Our Ref: JAH/SH

Application ref: P/12/15/PL

Land to the east of 29 Harbour Front Road, Pagham

Proposed erection of 3 detached bungalows, each with garage, parking and deck

STREET SCENE — Harbour Road.
with levels (A.O.D.)
Scale 1:100

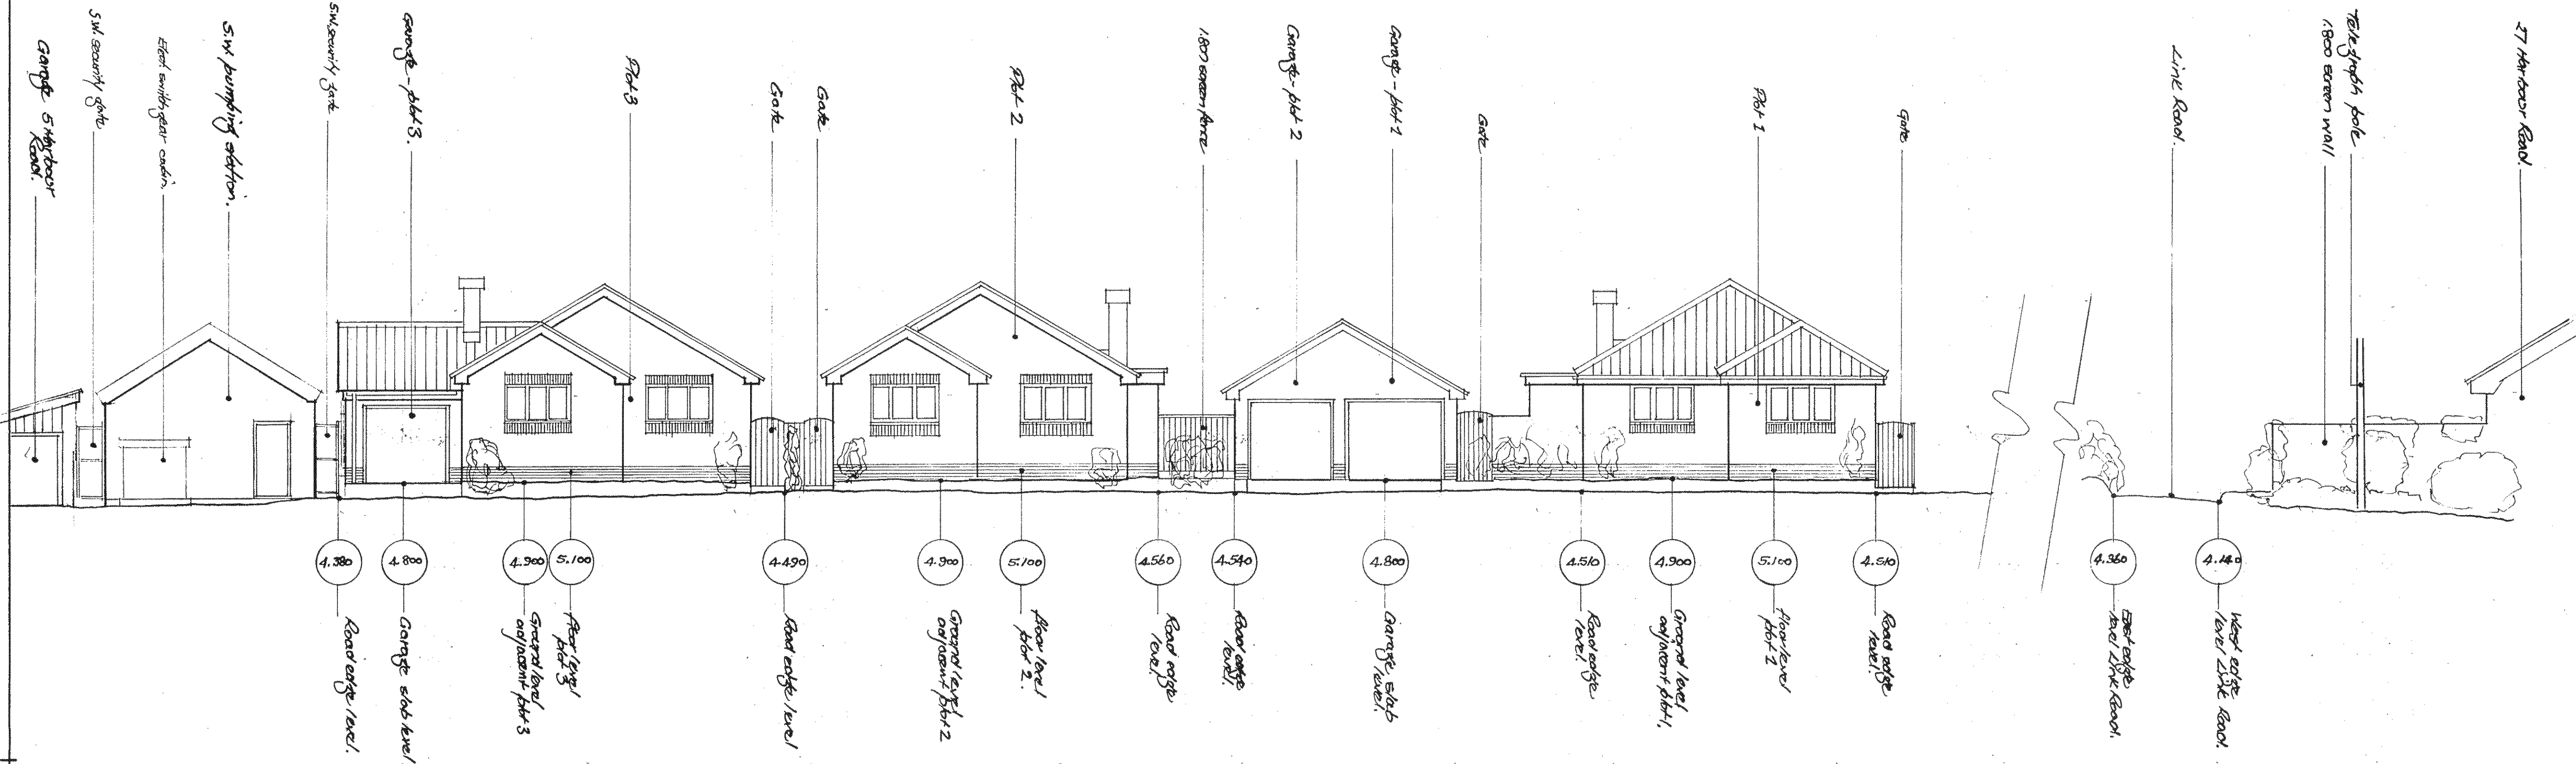
I also enclose as requested a street scene Drawing no. 05/109/07, with AOD levels clearly defined. This illustrates that the proposed development sits reasonably within the street scene and adjacent to the existing building and the dwelling at 27 Harbour Road. The proposed new bungalows, although slightly elevated to achieve a finished floor level of 5.100 AOD, are well below the limitation you imposed on the Sandy Road car park site.

Elevations:
Scale - 1:100

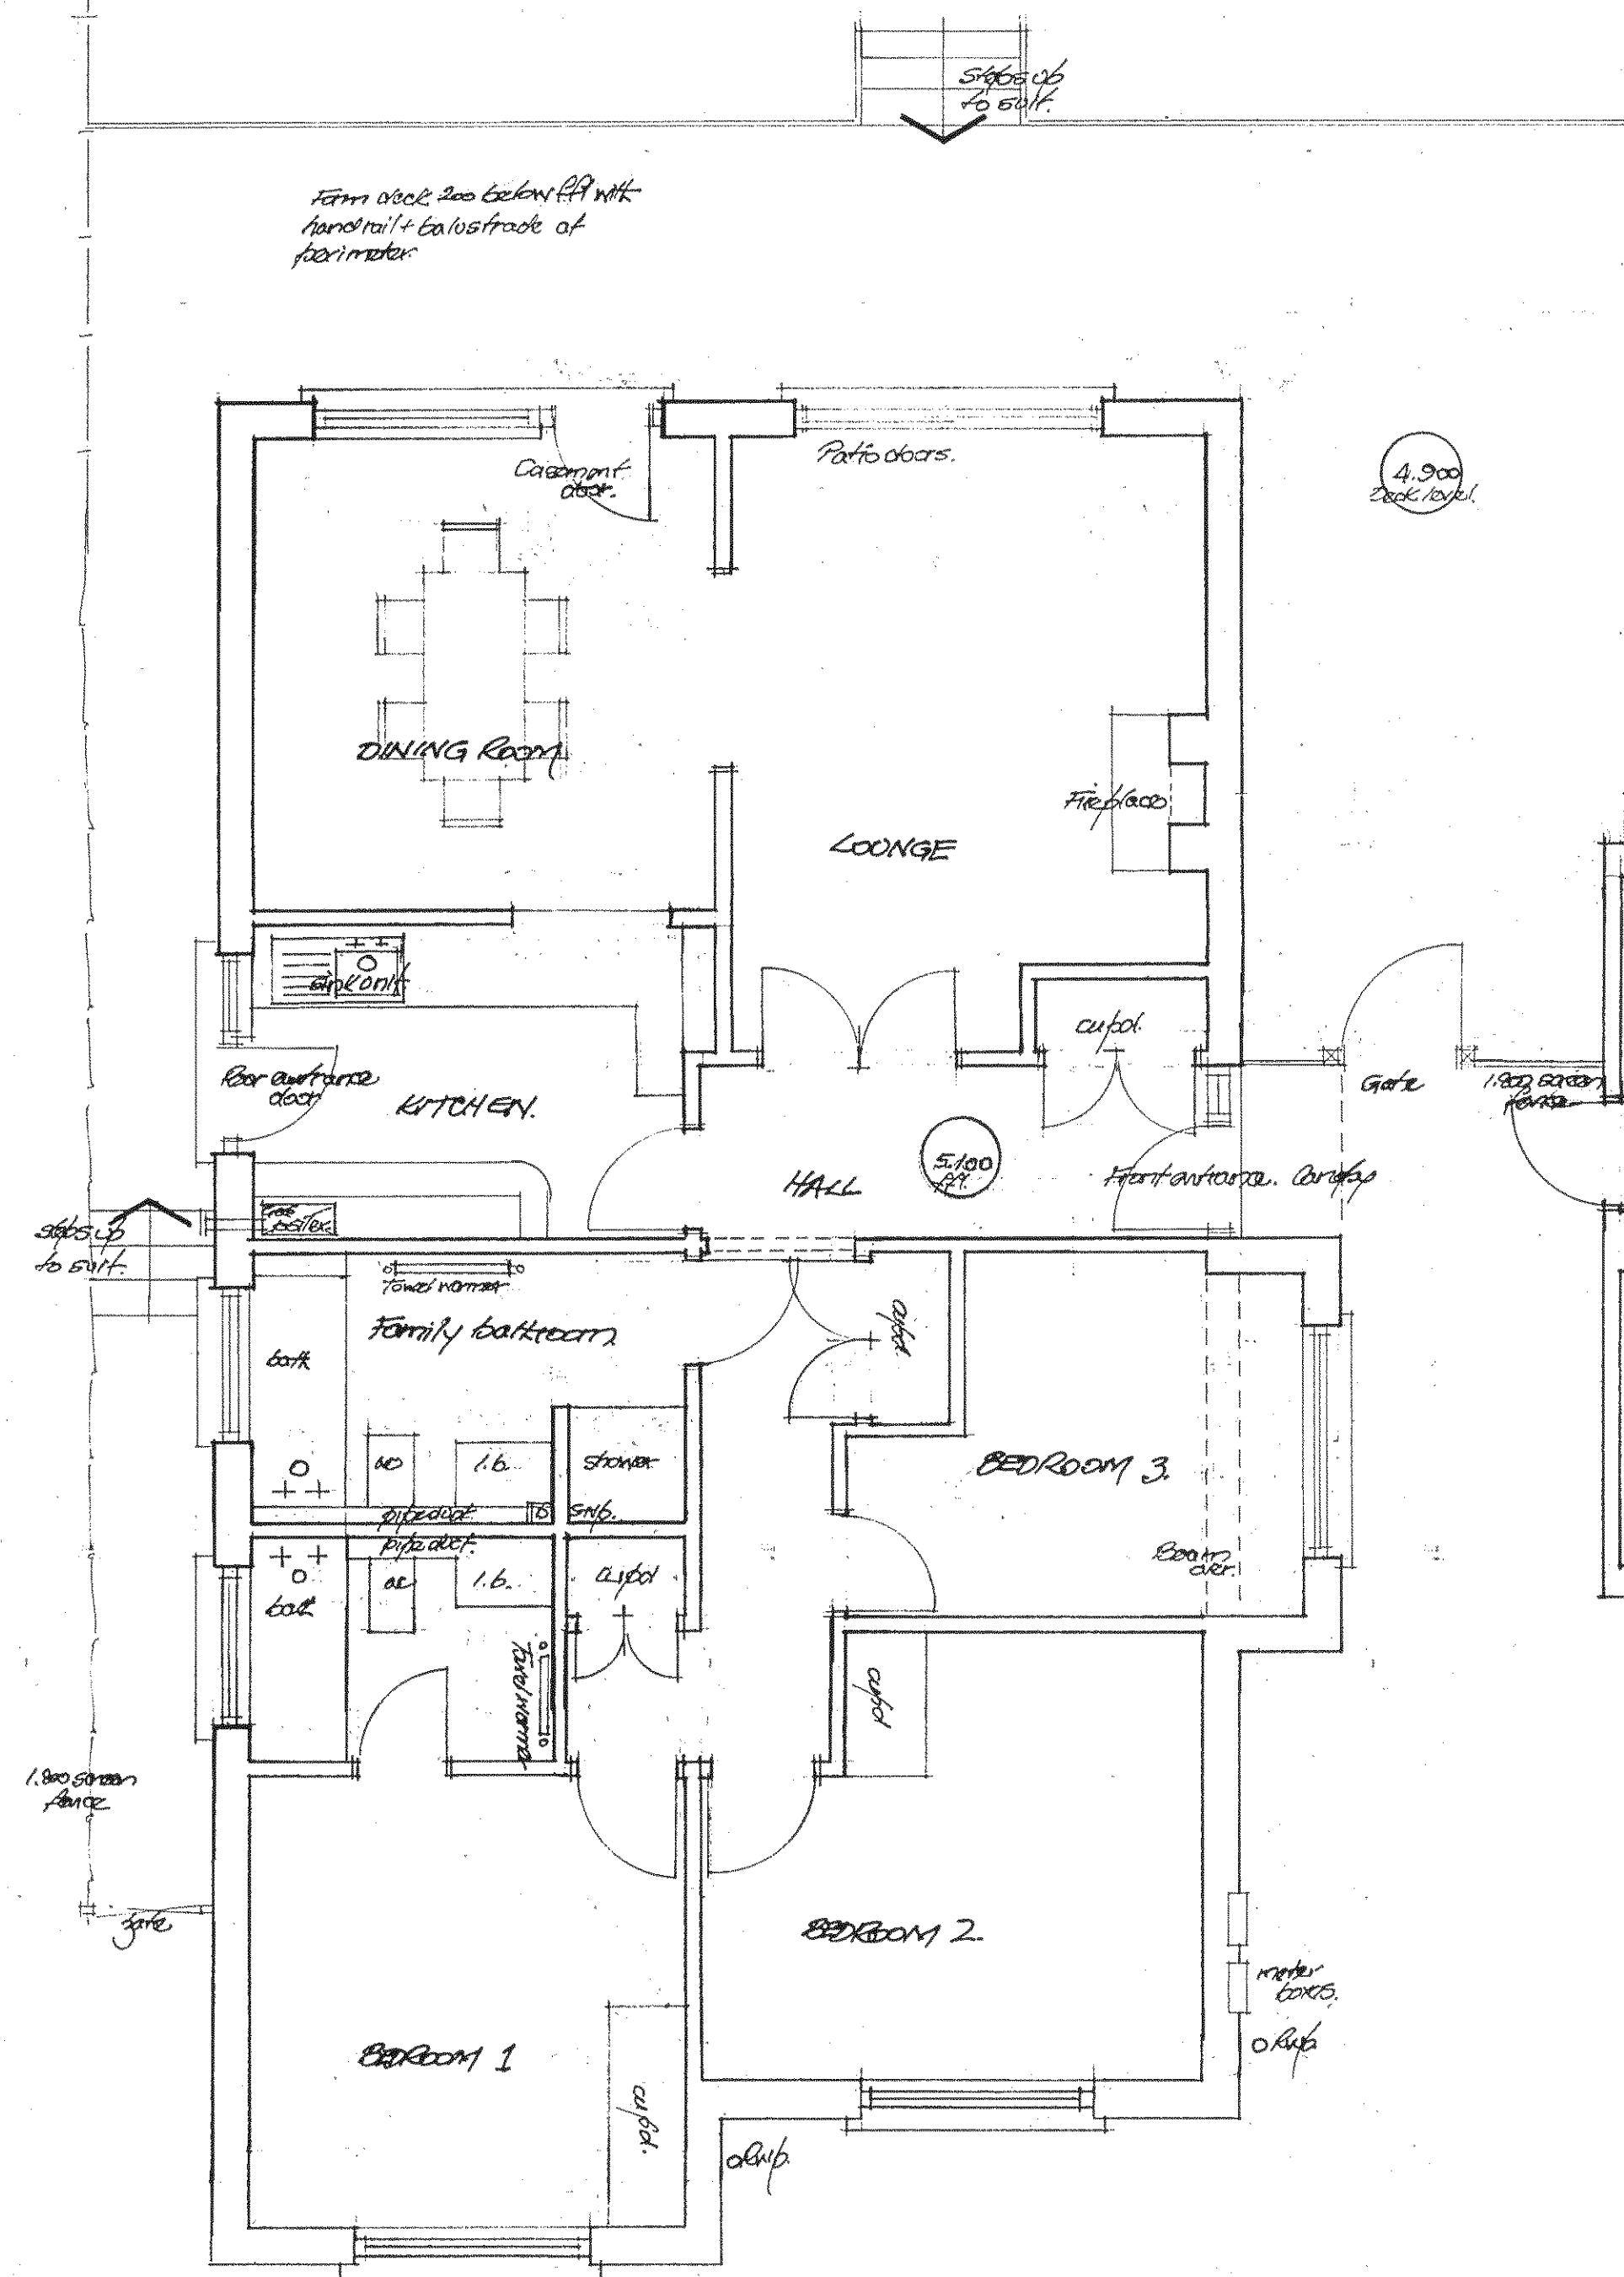
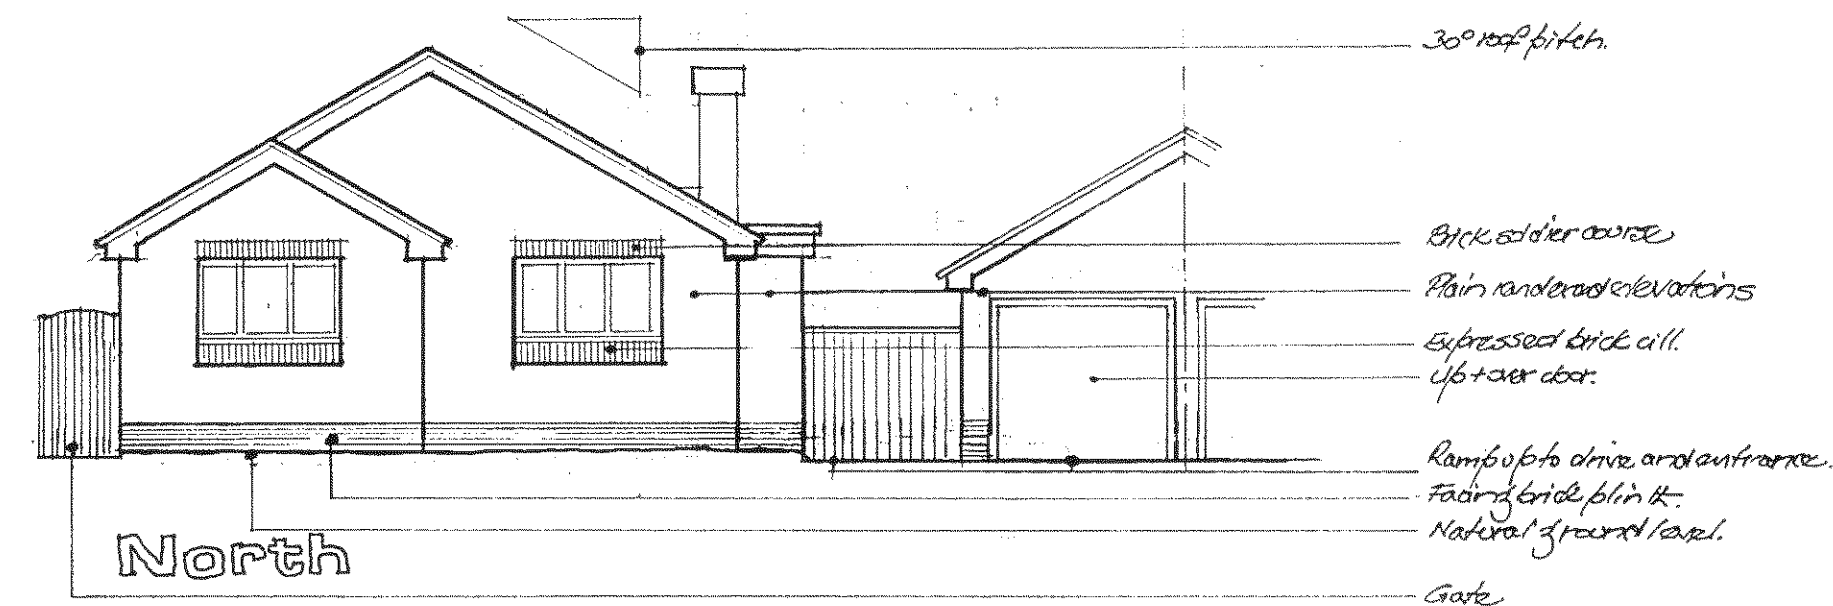
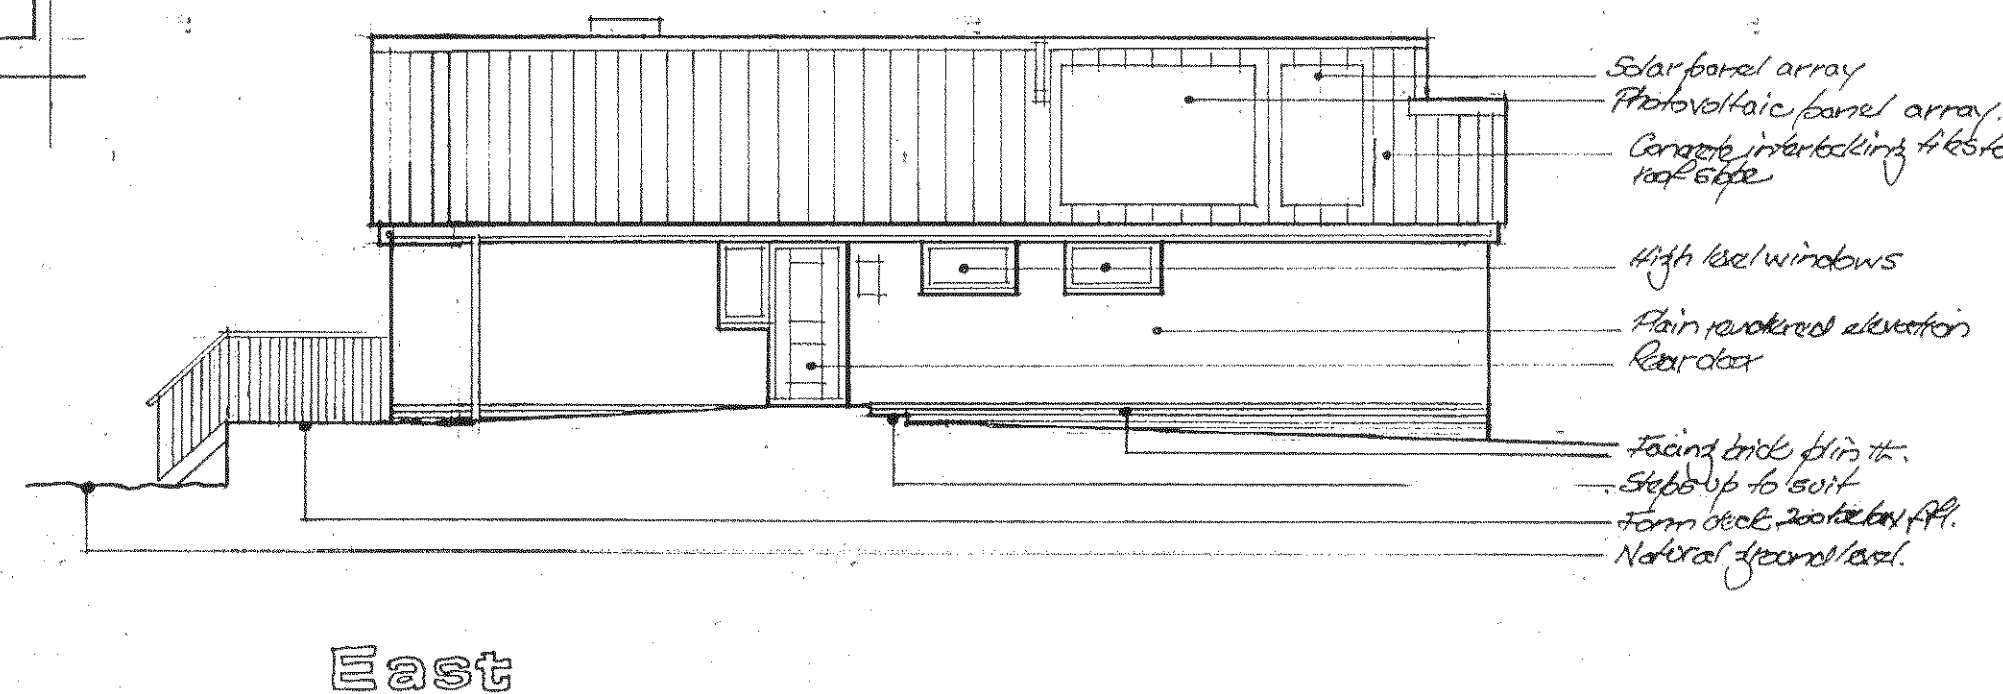
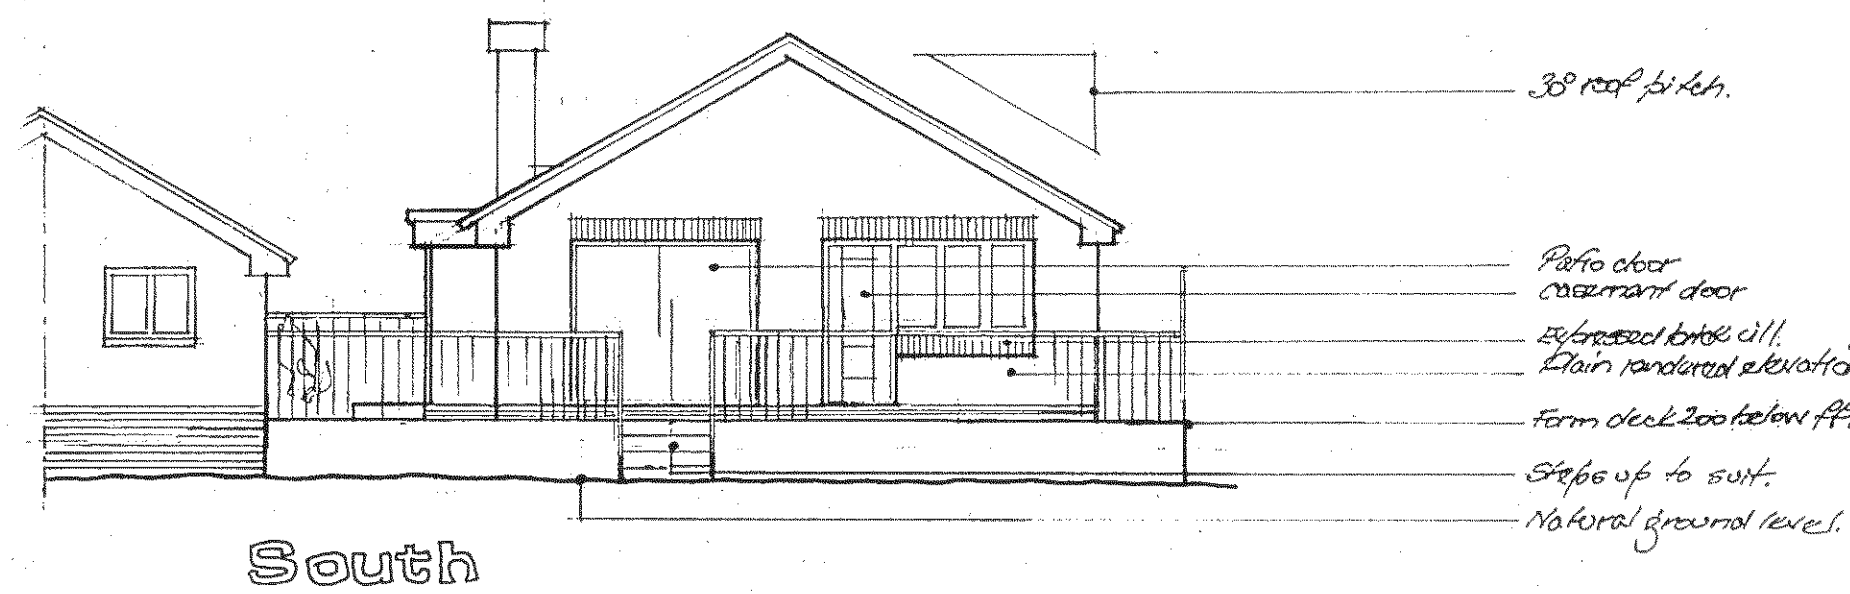
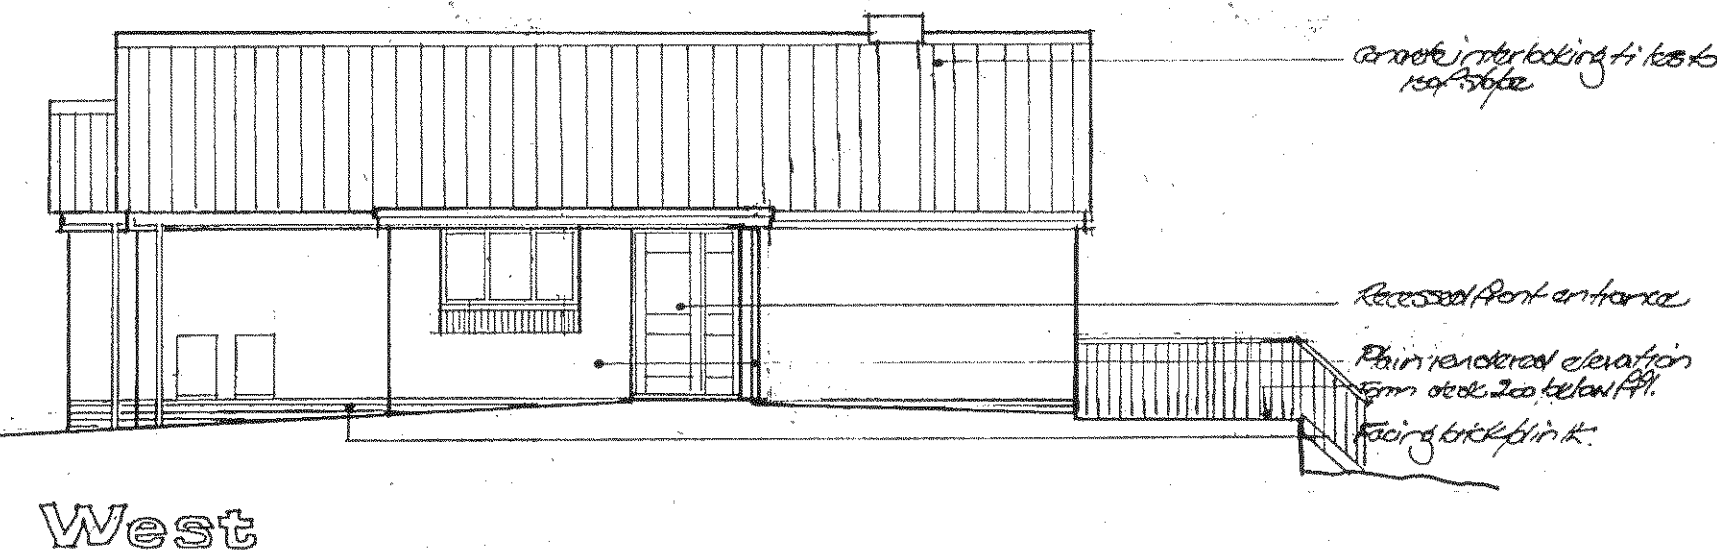
This change in finished floor levels and the AOD levels have also enabled the scheme to be amended and I therefore enclose for your attention two sets of Drawings no. 05/109/04E, 05E and 06E, which show the proposed bungalows with the revised AOD levels.

bungalows above natural ground level, it has been decided to reduce the finished floor level within the bungalows to 5.100 AOD, which I understand is the current minimum floor level accepted by Environment Agency. This was referred to in my e-mail to you of 28th April 2015, as follows:

I would mention that the current proposed finished floor level for the development at 5.500 AOD was based on the Application submitted in 2007 which complied with EA data at the time. Subsequently, EA has revised their recommendations to 4.800 AOD plus 0.300 freeboard, to give a minimum finished floor level at 5.100 AOD. For this re-submitted scheme, it was decided to provide an enhanced freeboard and retain the finished floor level at 5.500 AOD, but if that causes a problem with the visual appearance of the bungalows in the street scene, the finished floor level can be reduced to the current EA recommendation of 5.100 AOD.
